Date: 21 March 2024

Planning Act 2008 (as amended) – Section 51

Application by Mona Offshore Wind Limited for an Order Granting Development Consent for the Mona Offshore Wind Farm

Advice following issue of decision to accept the application for examination

LEGEND

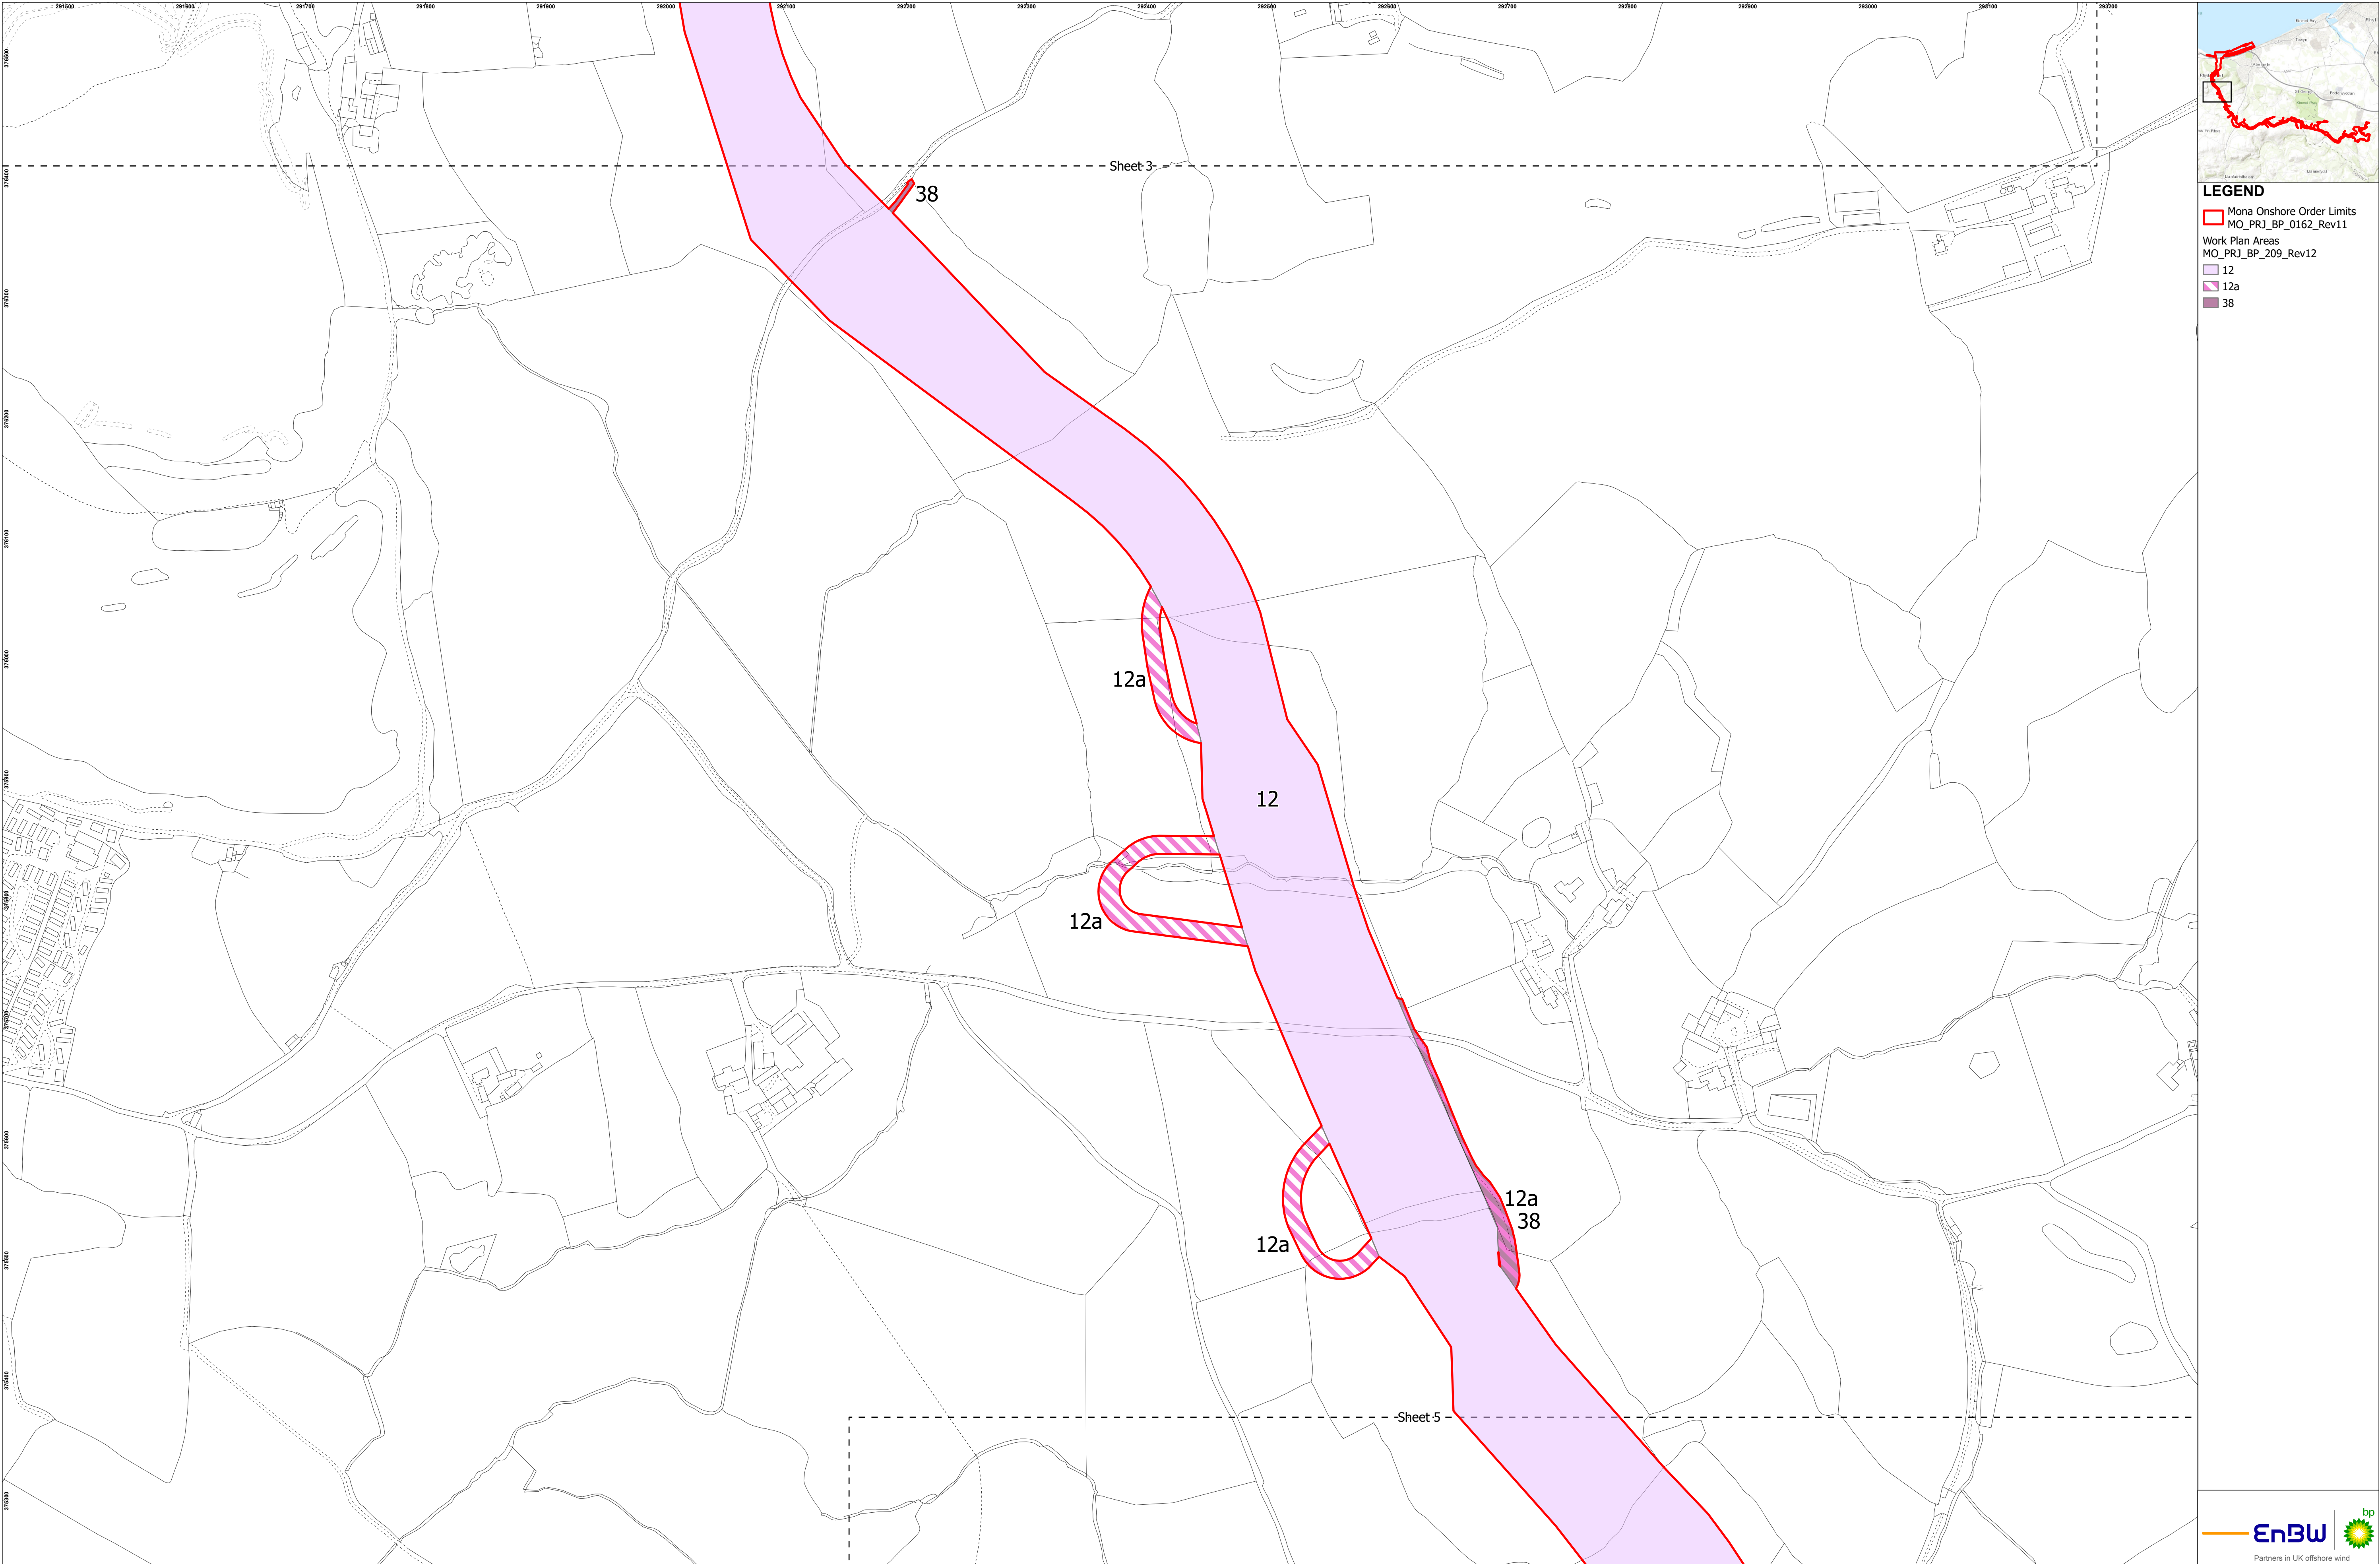
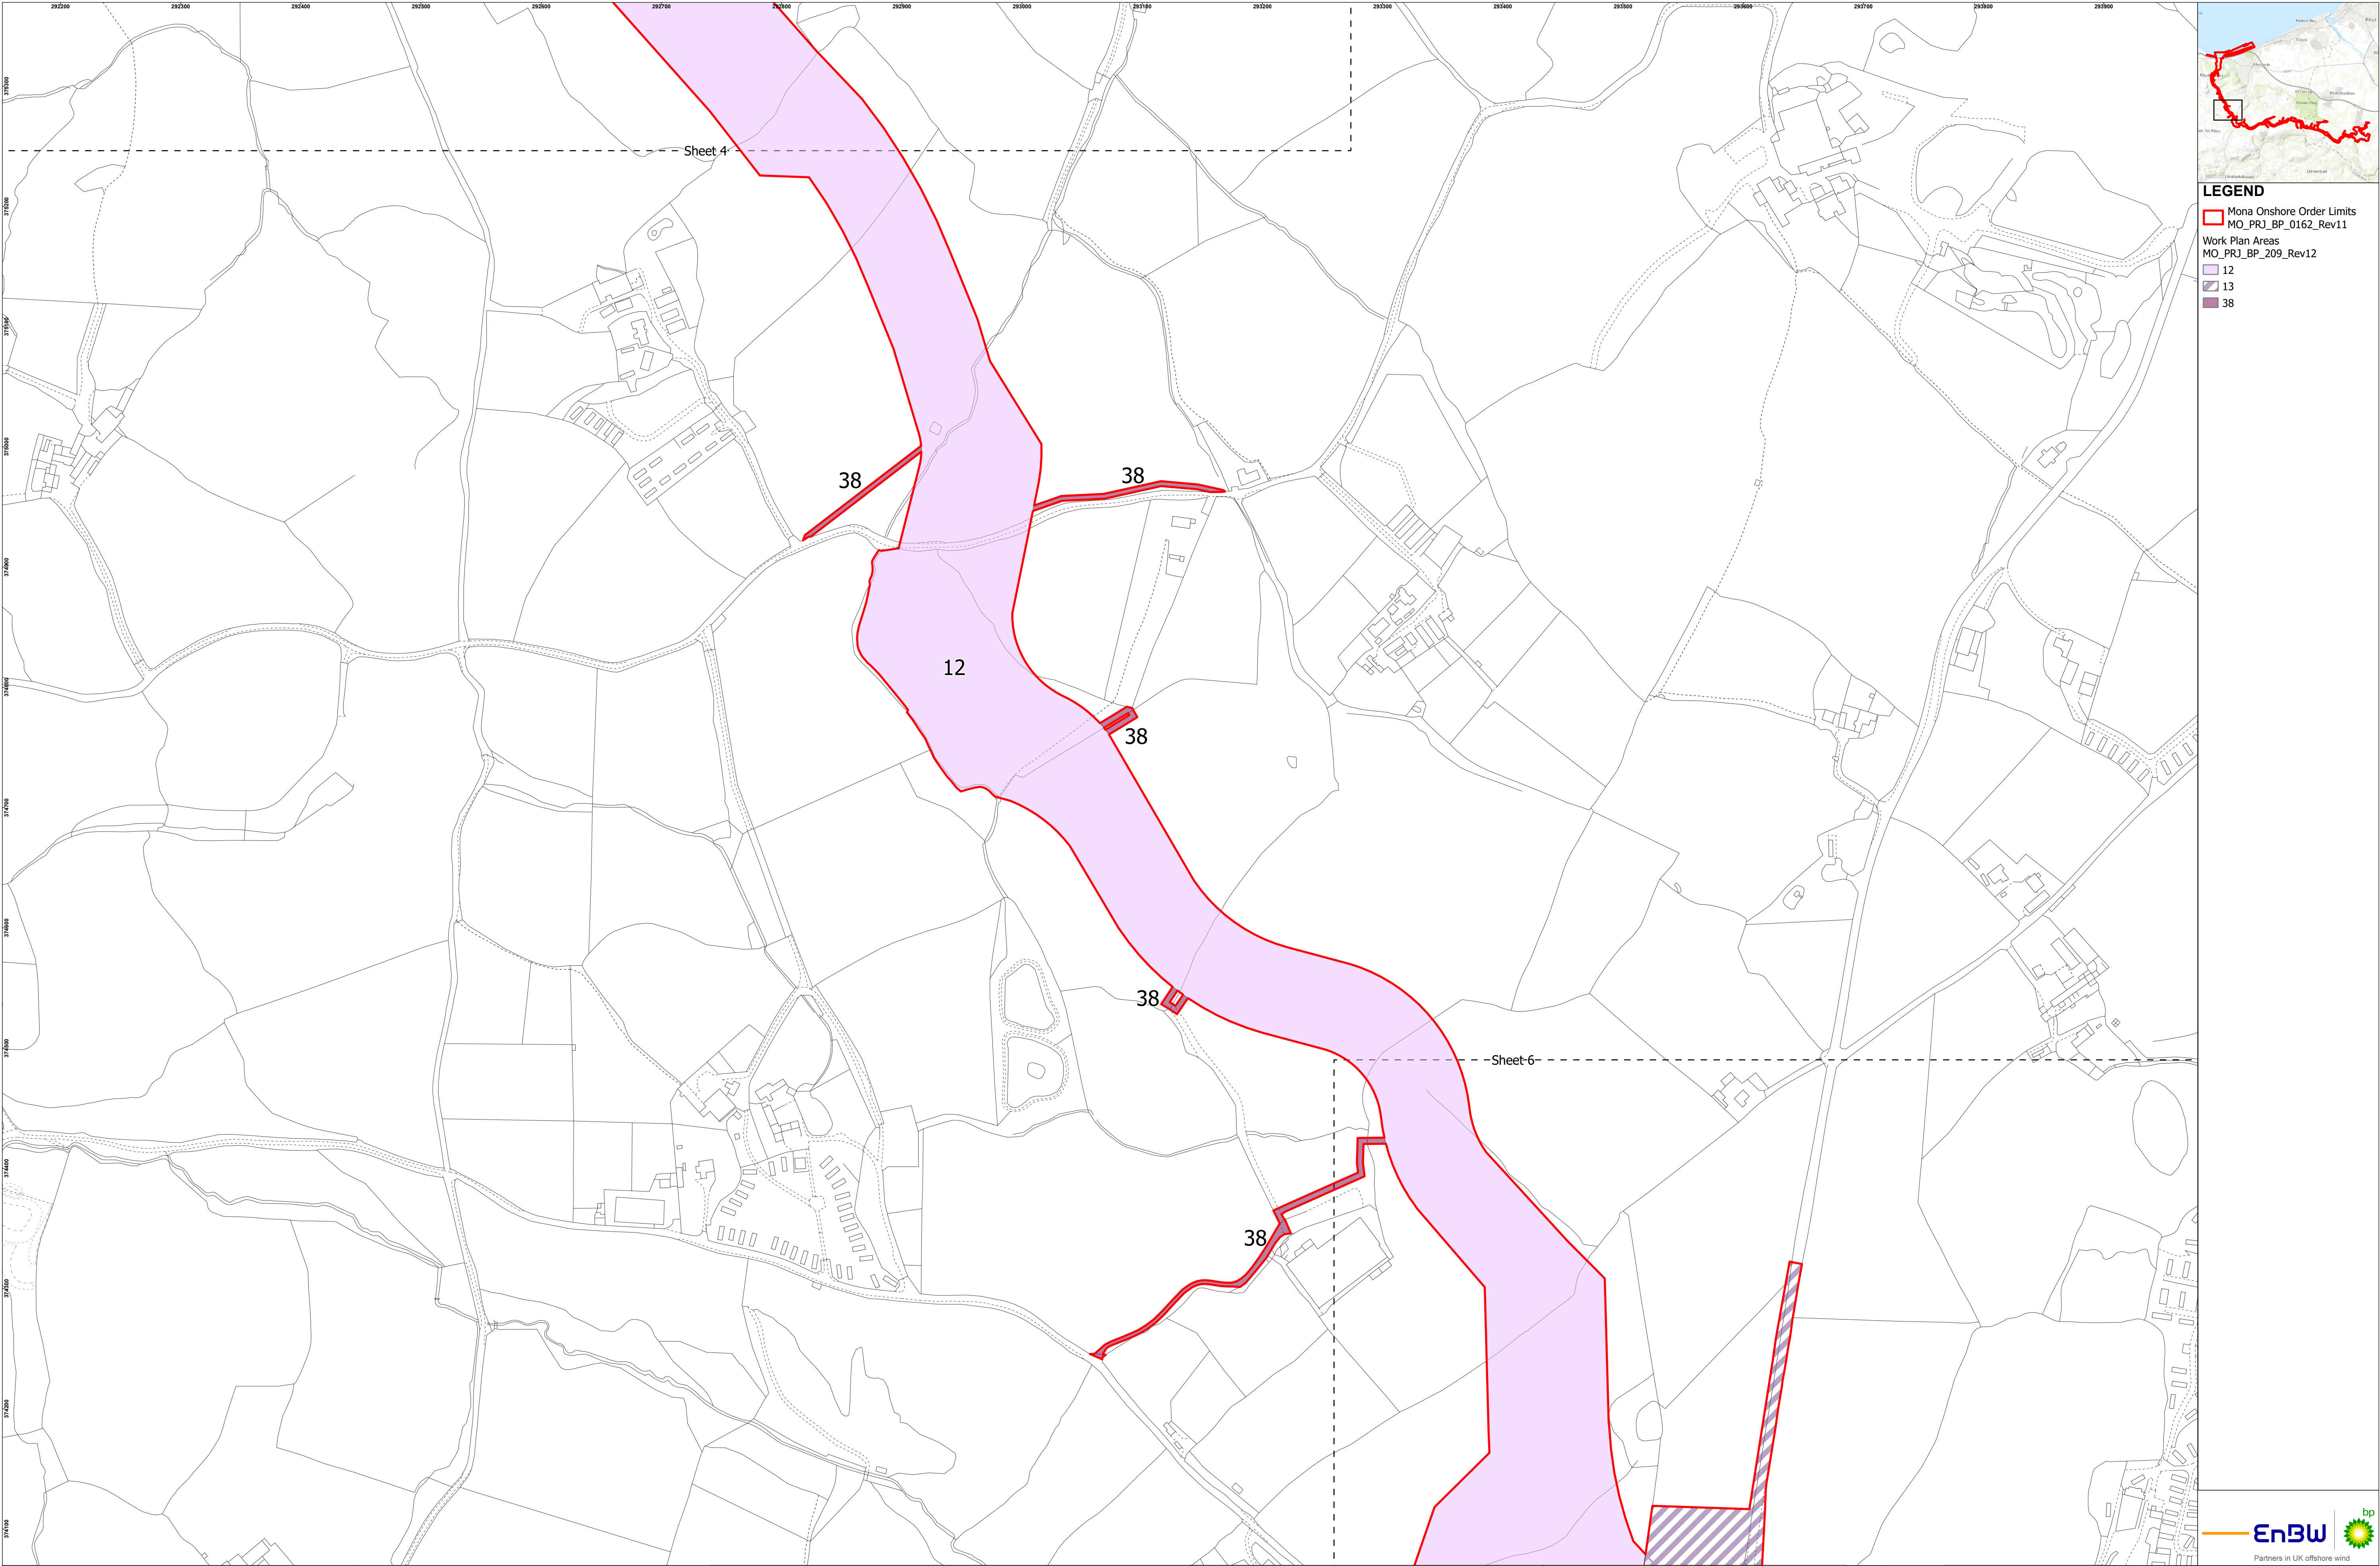
dDCO Schedule 1: Work No. 9 appears to erroneously refer to a connection between Work Nos. 3 and 10; it appears from the Works Plan that it should refer to a connection between Work Nos. 8 and 10. It would be helpful if this could be clarified.
